Re: Mortdale SSD 7421 Response to queries from the Department of Planning and Environment

Skylife Properties Pty Ltd has prepared a response to emails from the Department of Planning and Environment dated 26 September and 30 October 2017 seeking clarification on matters relating to the Mortdale State Significant Development application.

Stormwater Management
Plan

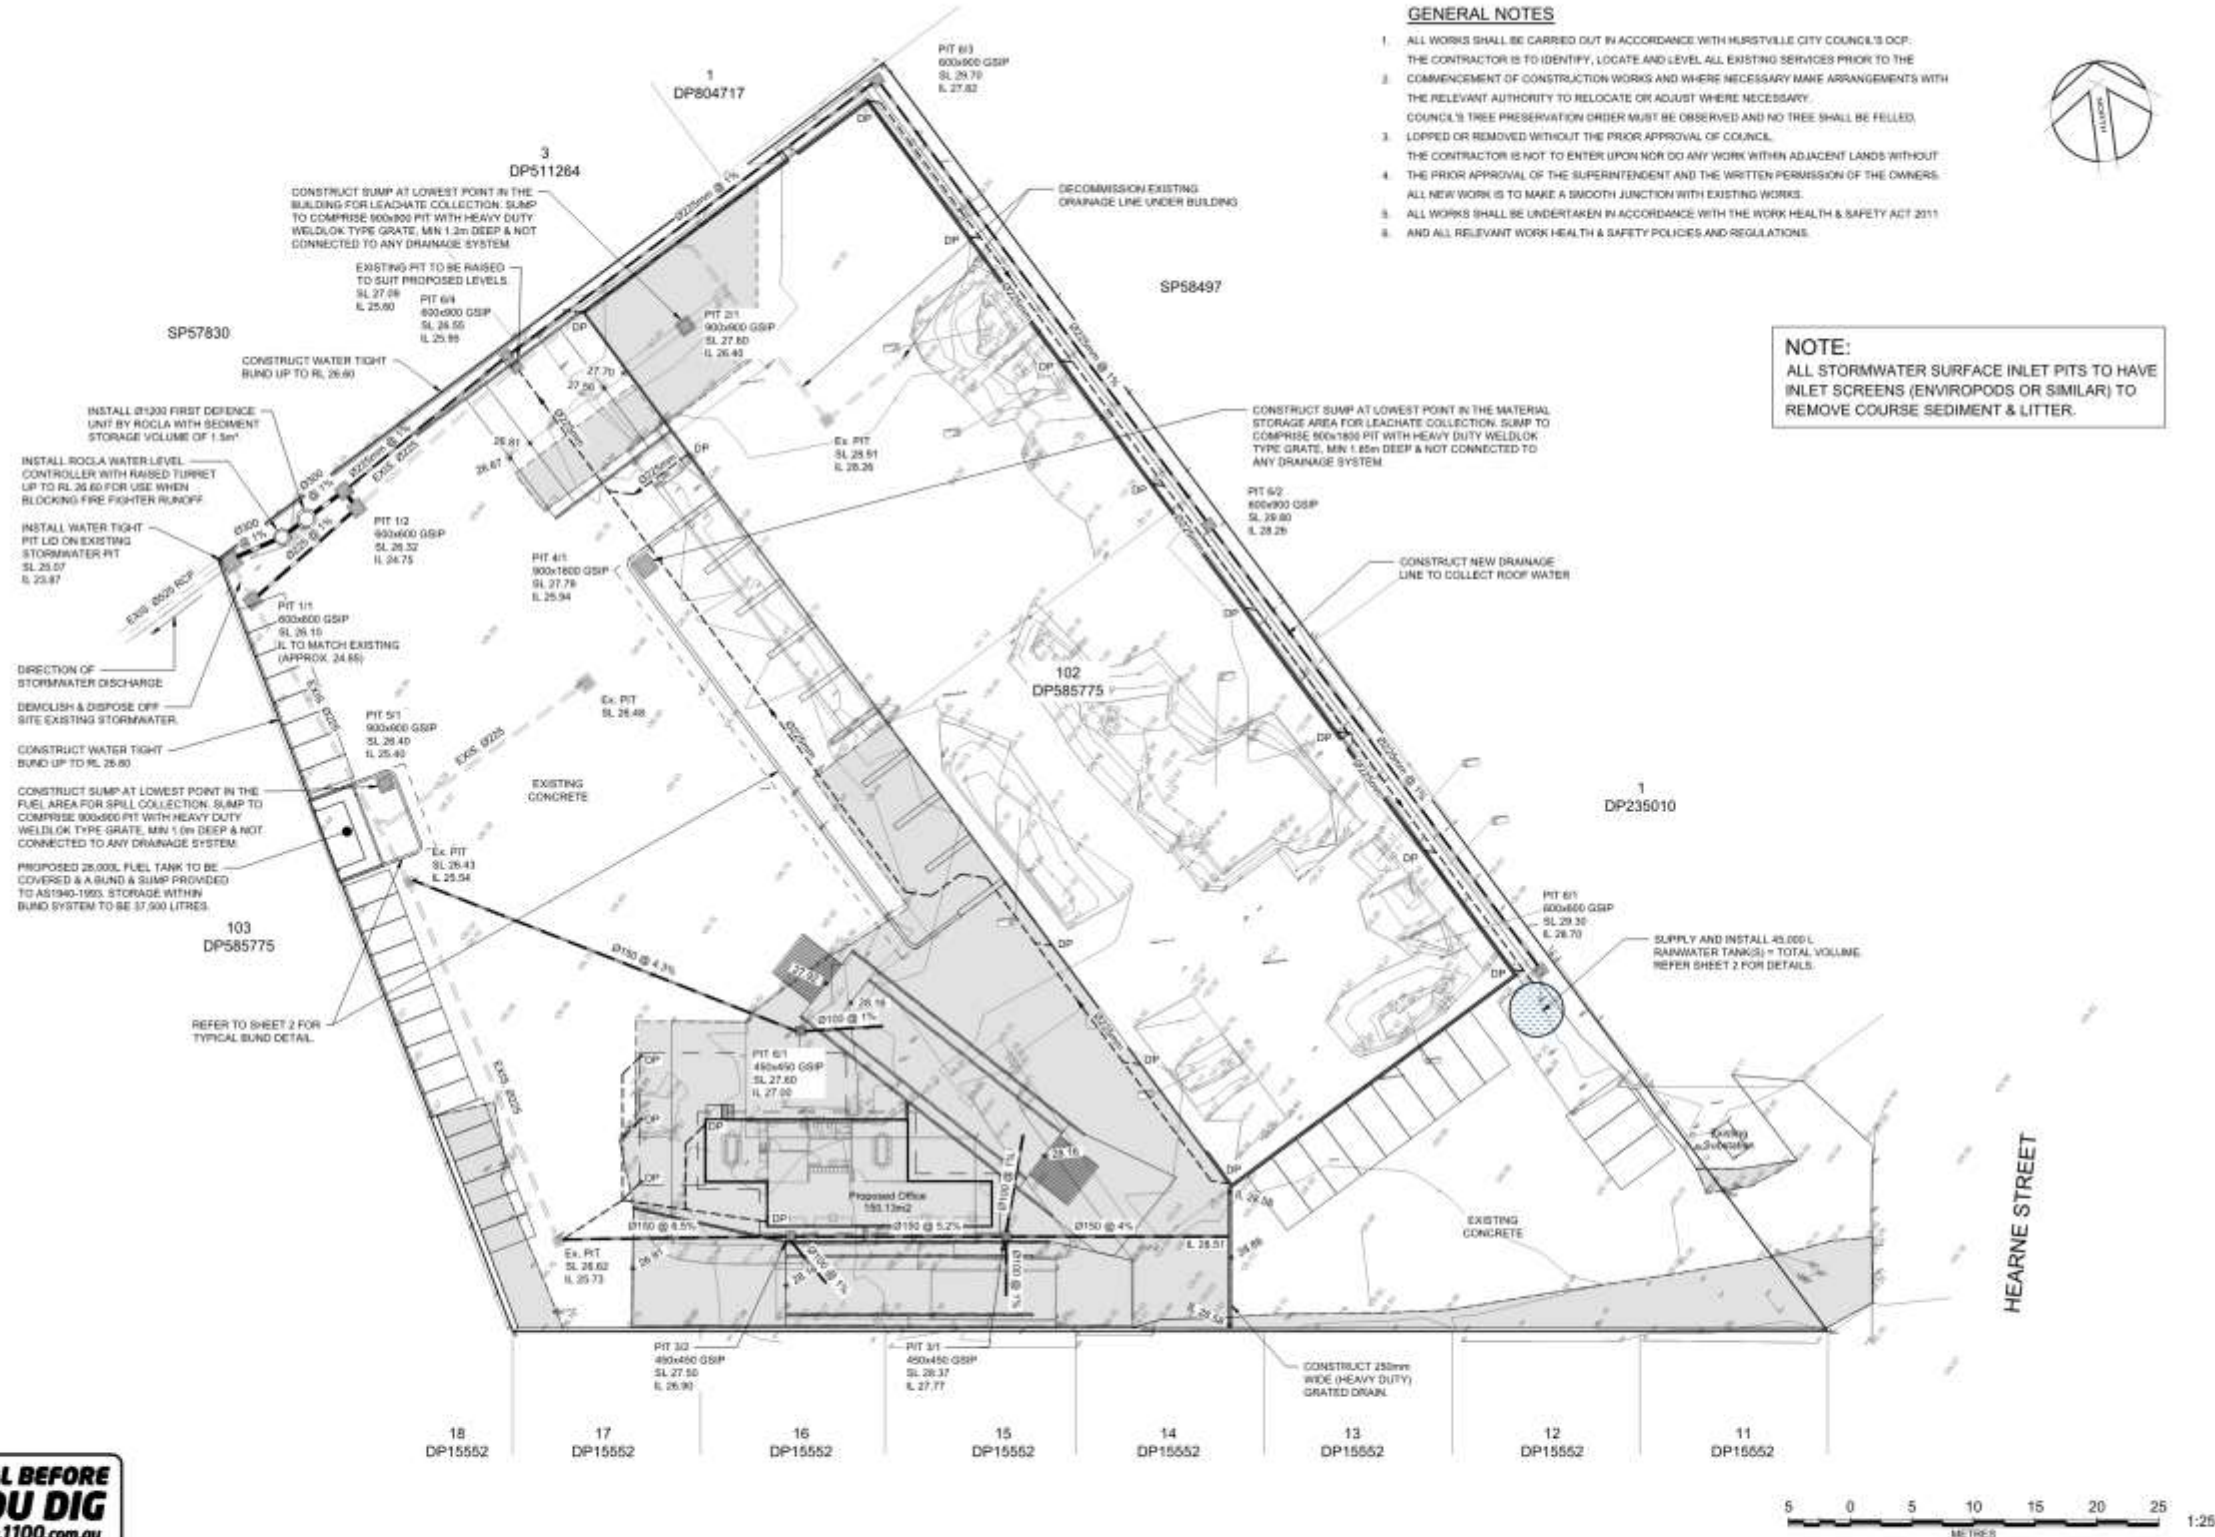
Whilst it is acknowledged that the predicted stormwater runoff volumes would not greatly change from the existing situation, adequate assessment of the proposed stormwater drainage system's capacity to cope with rainfall events has not been provided. It should be noted that the Georges River DCP (Section 3.7) requires onsite stormwater and drainage control to be designed for the 20 year ARI storm, with overland flow paths designed for the 100 year ARI event. Details of all modelling (e.g. DRAINS) of the stormwater system should be provided.

A review of councils DCP covering stormwater does not appear to provide clear guidance with the following points being provided within the DCP under the heading of On Site Detention;

- That Appendix 2 is an old document that should have been updated when the DCP was revised.
- That if the proposal is submitted to council, that despite what Appendix 2 indicates that they will require OSD.

- That the increase in impervious surface area is in the order of 375 sqm.
- The bunded area associated with the storage area located in front of the building is 342 sqm which drains to a contained pit that does not drain.
- And half of the roof area of the factory building will be directed into a 45,000 L rainwater tank and drawn from an ongoing basis to supply water for the factory's internal fogging device which suppresses dust formation.

Given this, it is believed that the stormwater disposal from the site will generally comply with the following clause from the DCP under the heading of "Design Solution".

- Use of Rocla's First Defence unit;
- 45kL rainwater tank and associated drainage to collect runoff from approximately half of the roofed area;
- Installation of bunds to surround product bays under the shed awnings to both prevent stormwater runoff entering the into material storage area under the awning and prevent leachate from coming into contact with stormwater; and
- Gross pollutant screens are currently fitted to all stormwater pits and litter baskets will be retrofitted into all inlet pits onsite to improve treatment performance.
